Subject: Application Ref: BR/79/21/PL - 83 Aldwick Road, Bognor Regis, PO19 2NT, West Sussex

We have some very serious concerns regarding the proposed development at No 83 Aldwick Road, and wish to raise our **Formal Objection to this development.**

Regarding the proposed development Ref: BR/79/21/P :

amendments	
client	SPP
project	83 Aldwick Road Bognor Regis PO21 2NT
project ref.	2446
drawing title	Existing plans
drawn by	DH
date	DEC 20
scale	1:50/100@ A1
	www.bpmnet.co.uk info@bpmnet.co.uk
Do not scale off drawing, check all dimensions on site before all work is commenced

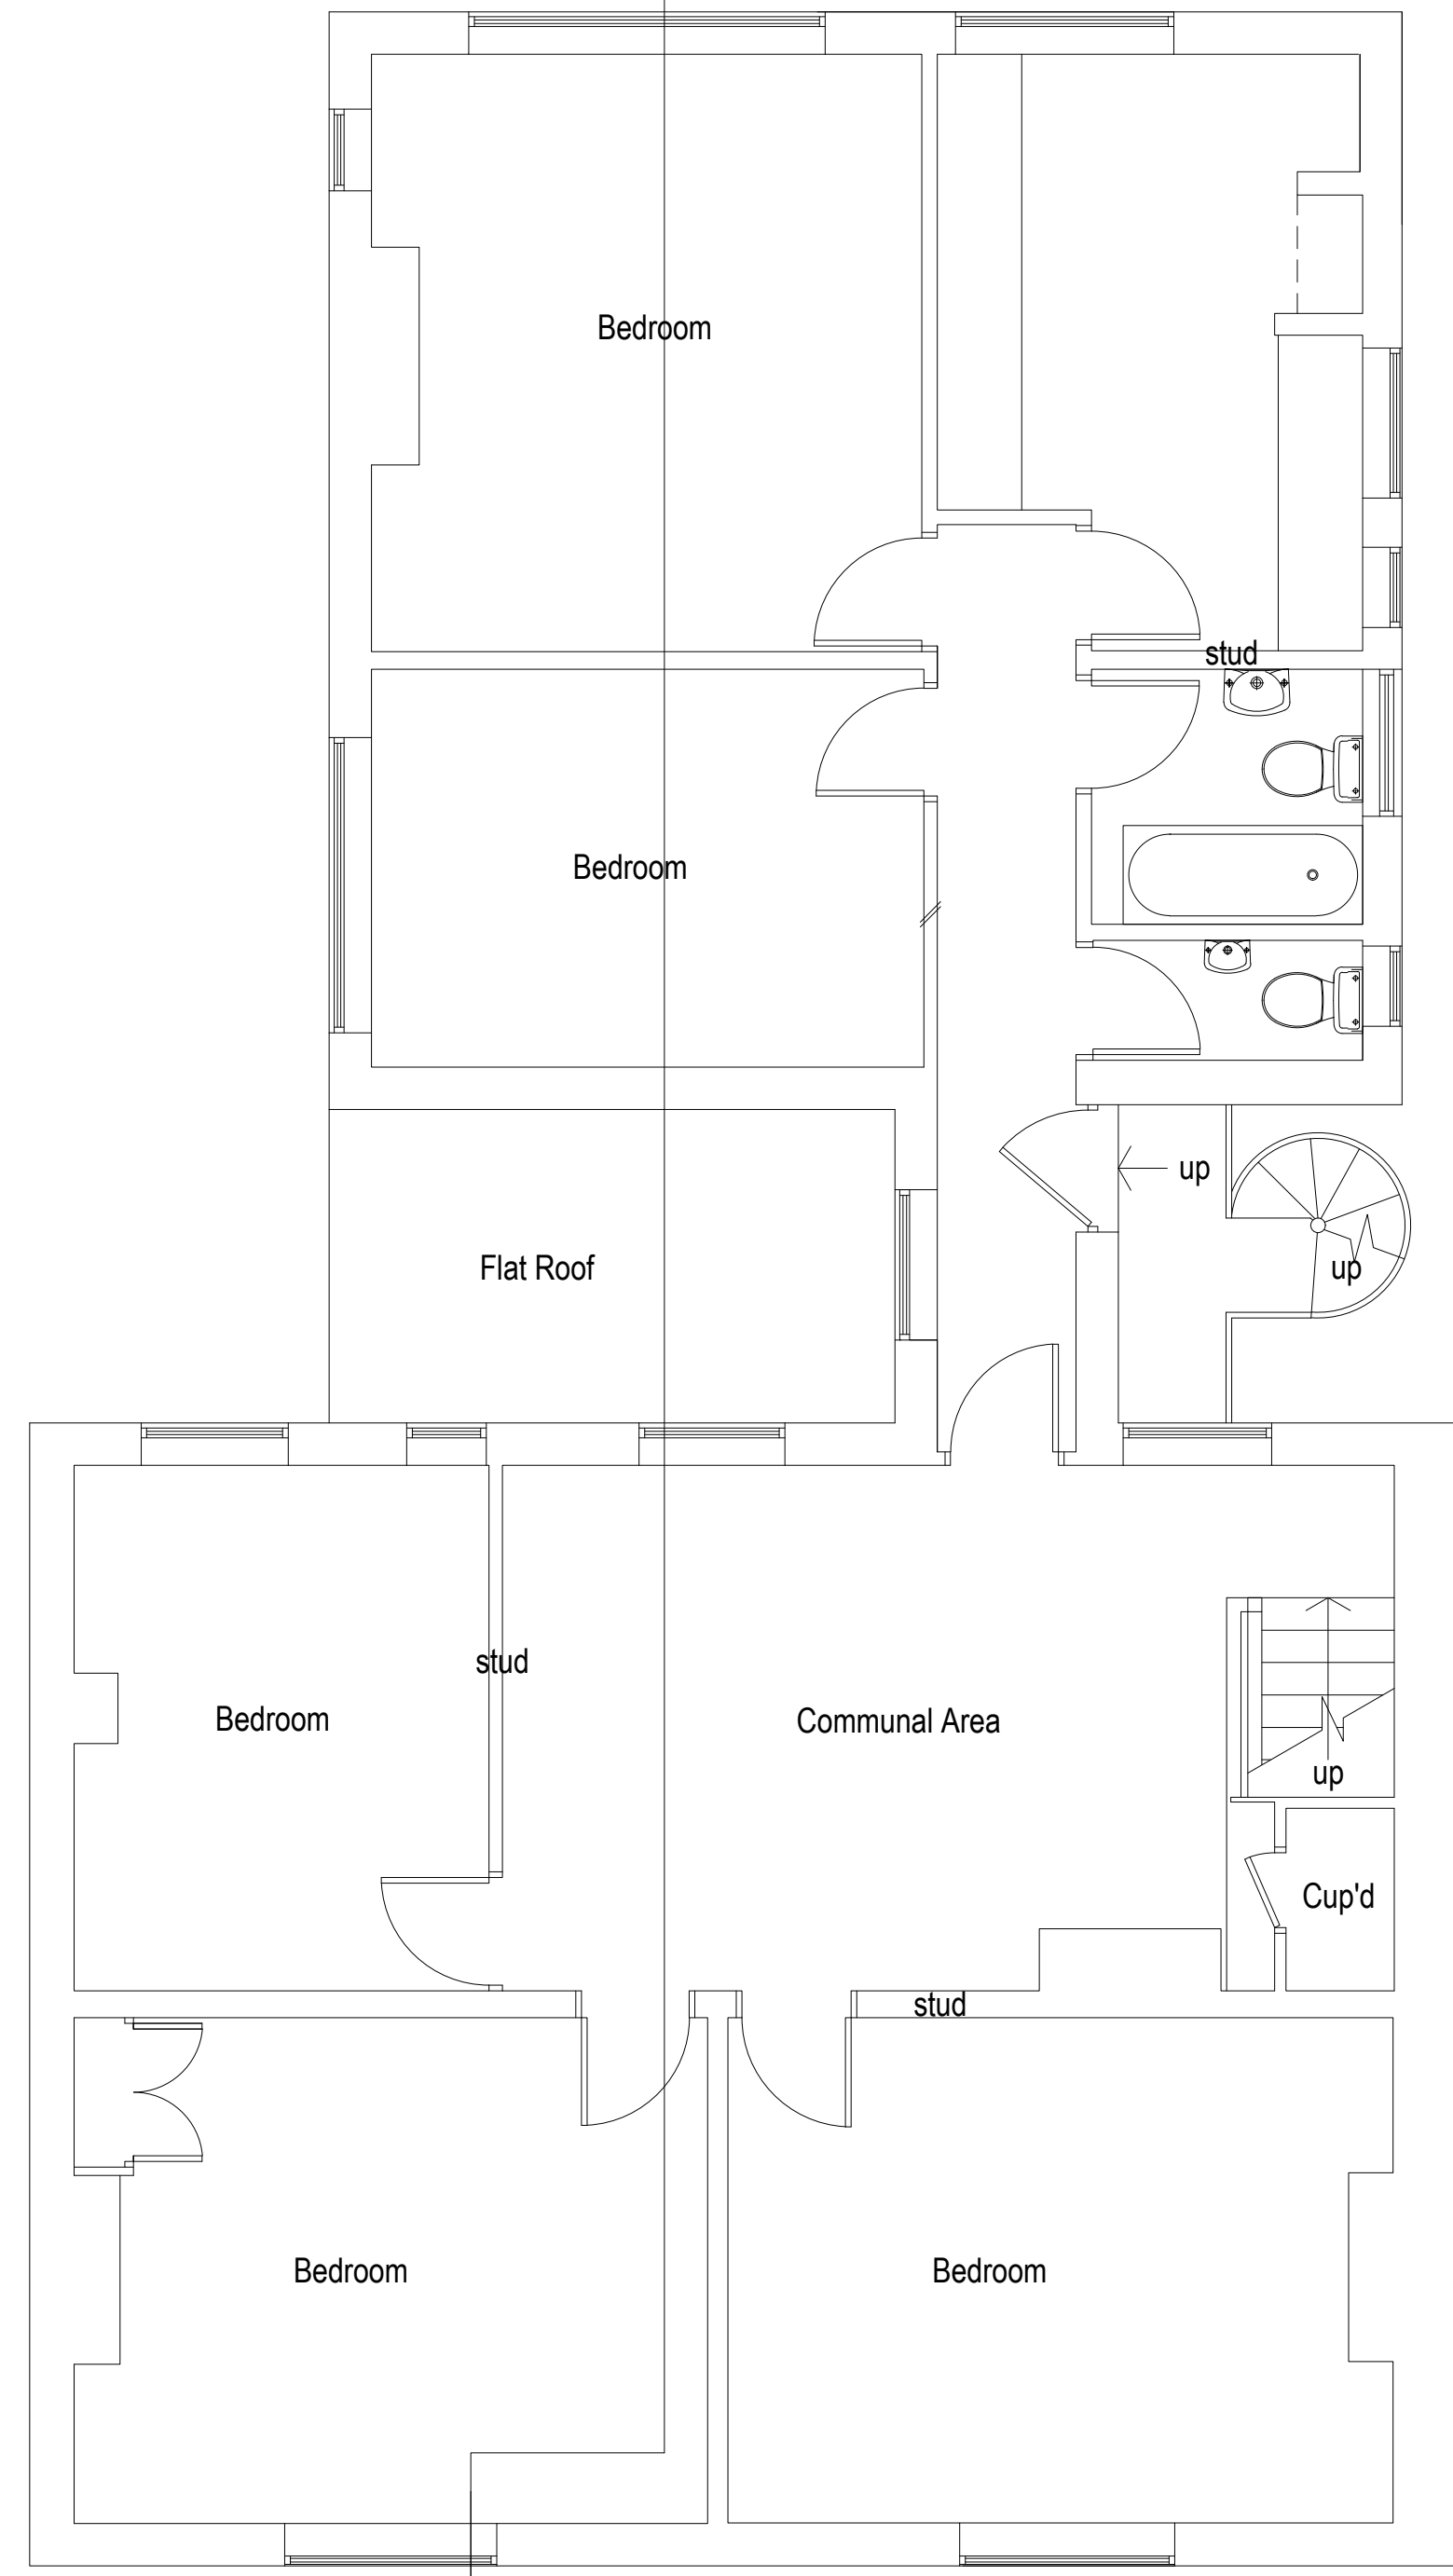
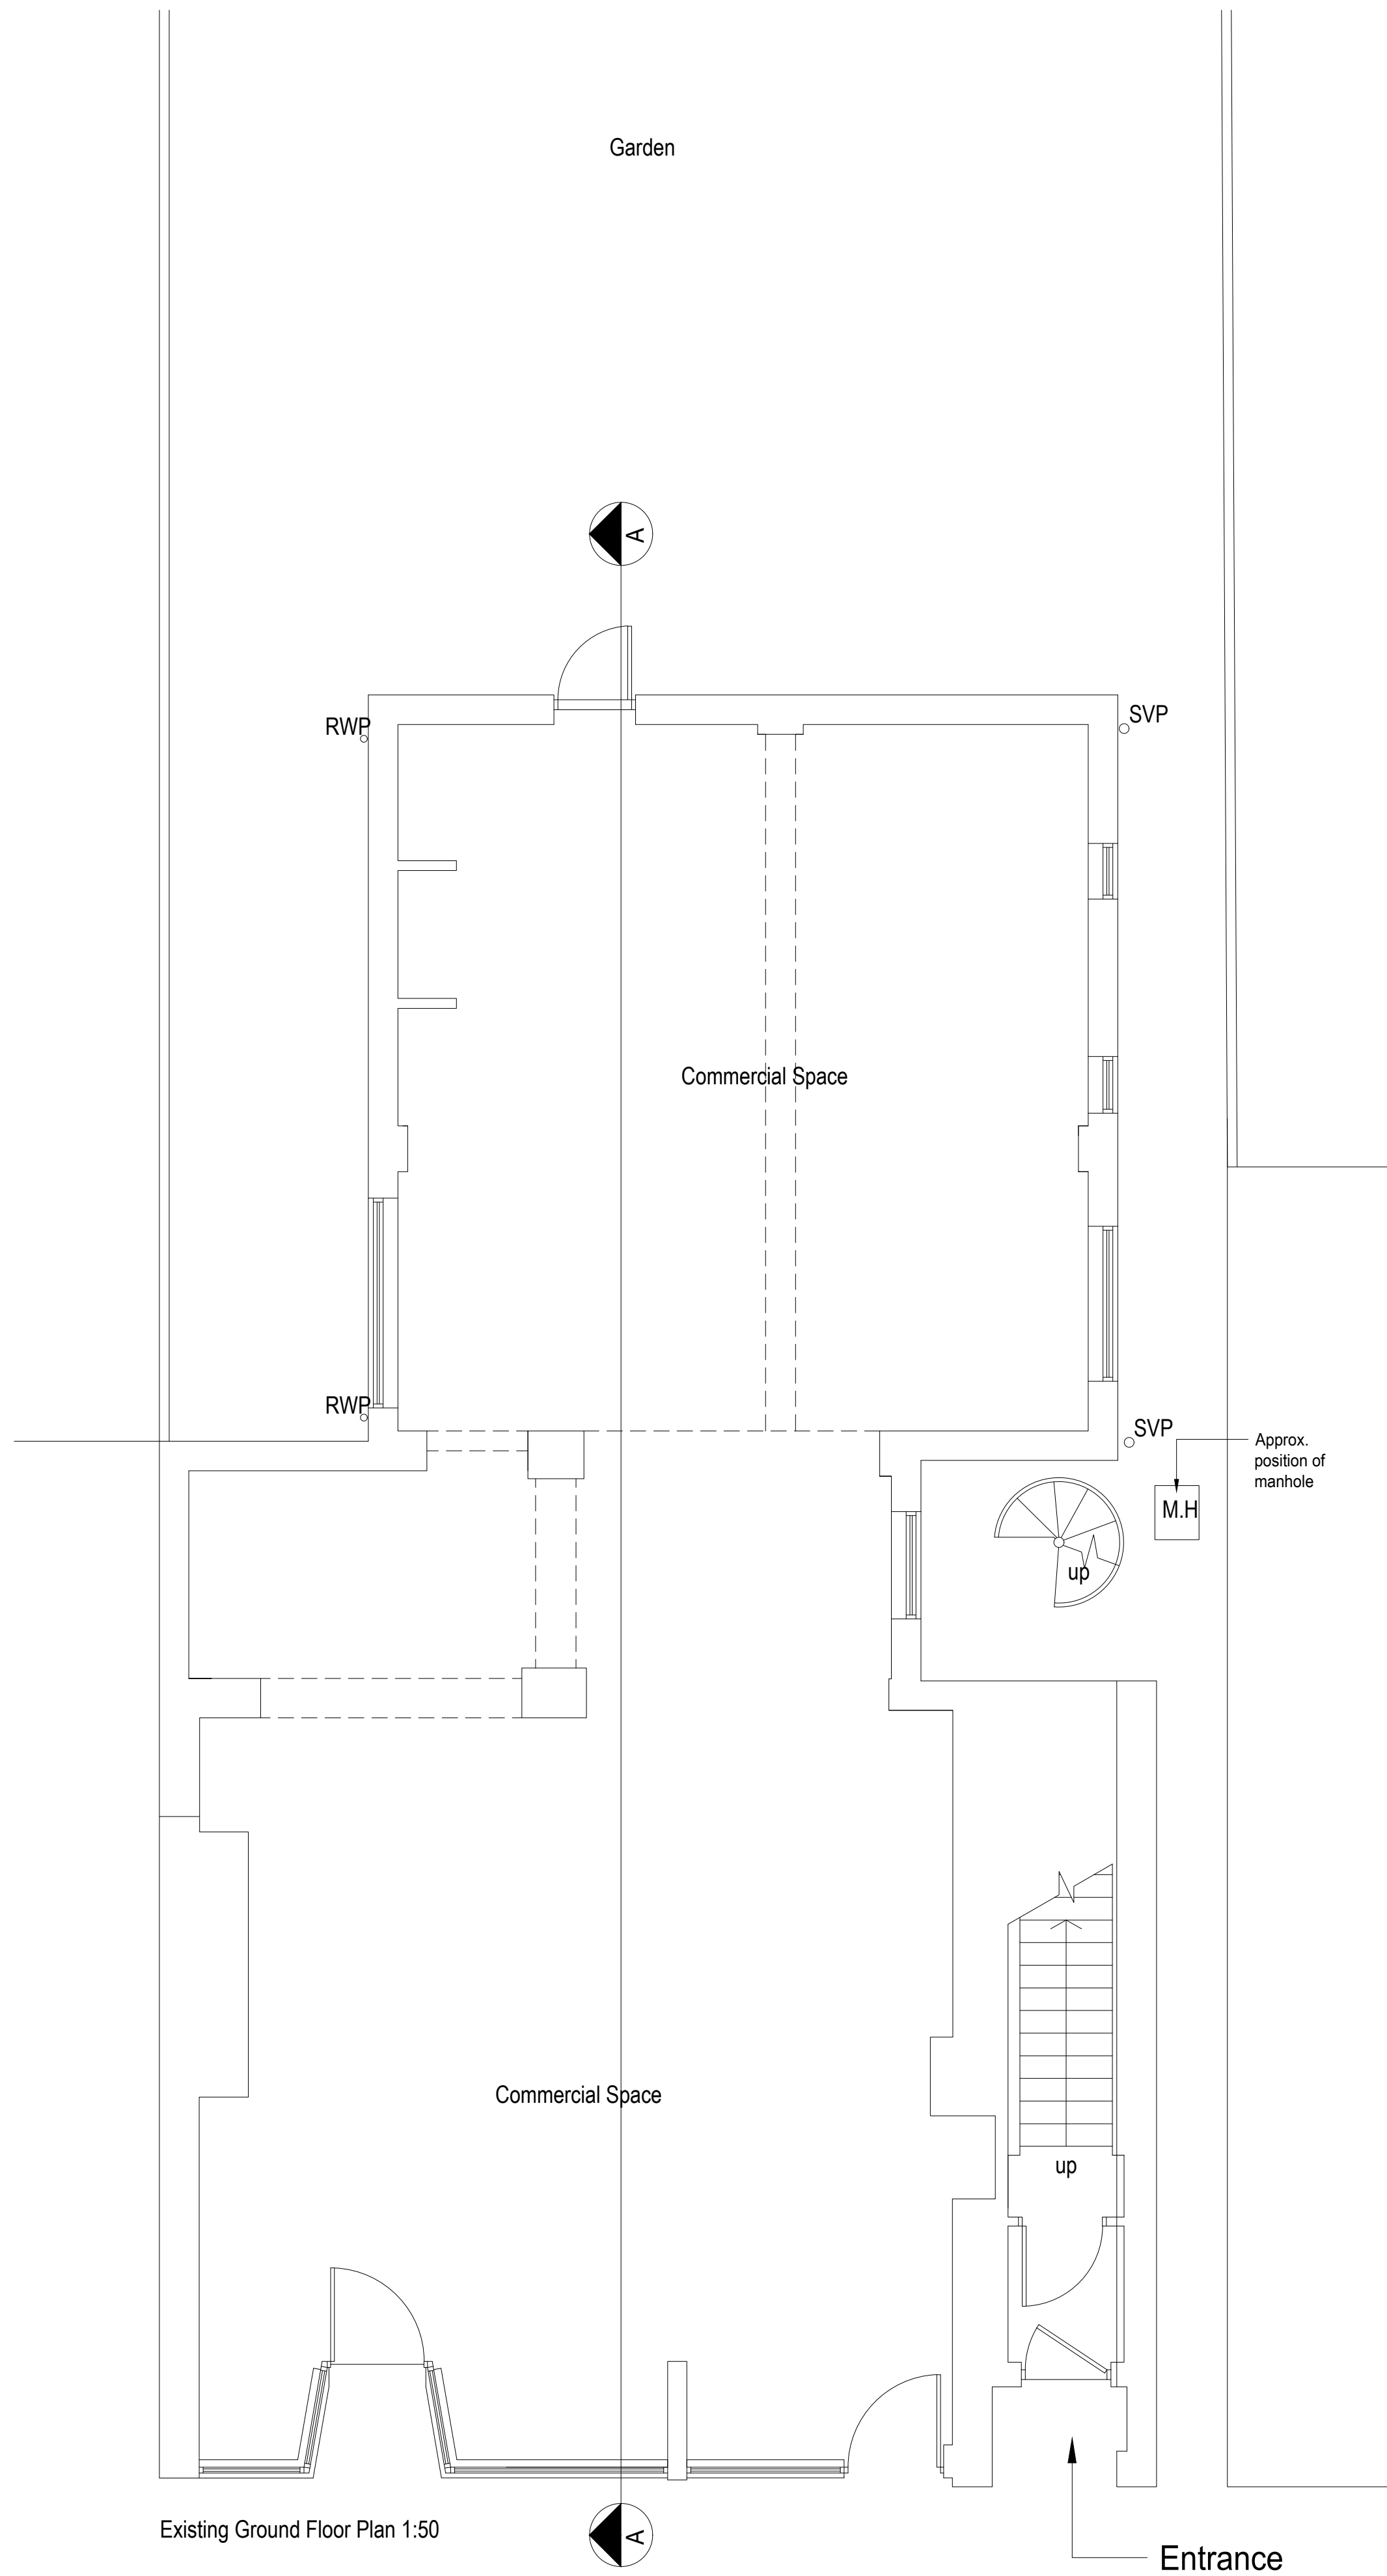
1. The proposed increased height of this building will very significantly block the views, light and air, to the residential flats in our building (No. 81). The residents in our building are generally young families / professionals.

2. The privacy to these flats will also be adversely impacted. In fact we have already had concerns expressed by tenants in our flats that if the proposed increased height of building at No 83 were to proceed, they plan to vacate our property. Their views from their flats have always been far reaching. (see photos View from Flats...001 to 003).

3. The proposed introduction of additional windows facing from No 83 to No 81 will also negatively impact privacy.
4. These problems are further accentuated by the close proximity of building No 83 to our building no 81 (see photos / plans Driveway and Boundary Wall)
